Application for a Non-Material Amendment Following a Grant of Planning Permission

42 Painter Wood

3/2020/0163

ALTERATIONS TO THE FRONT ELEVATION CLADDING INCLUDING THE TIMBER BOARDING AND CHANGE FROM RENDER FINISH TO CORTEN STEEL CLADDING TO THE LOWER FRONT BALCONY WALL

A300

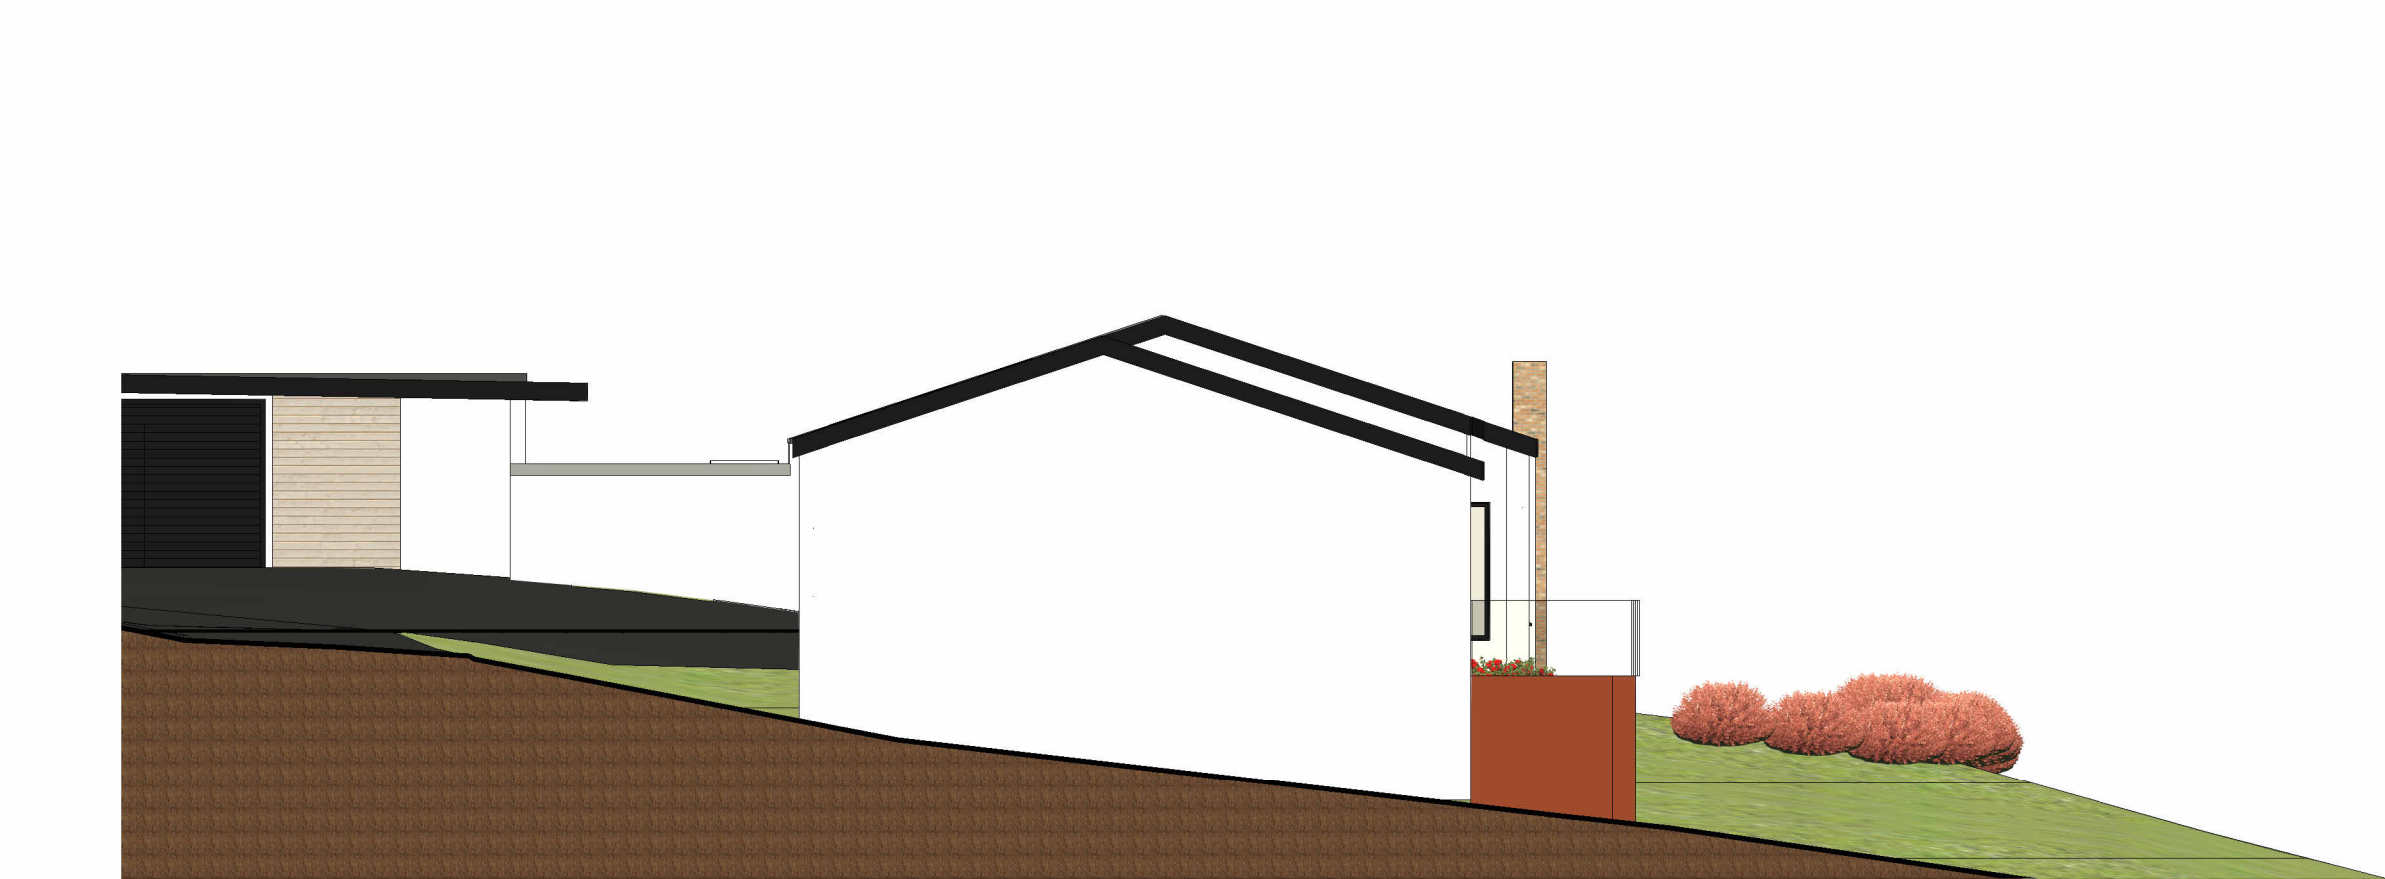
TO REGULARISE THE AS BUILT SITUATION AND THE RENDER IS STAINING

AS BUILT ELEVATIONS SHOWN AND DESCRIPTION AMENDED
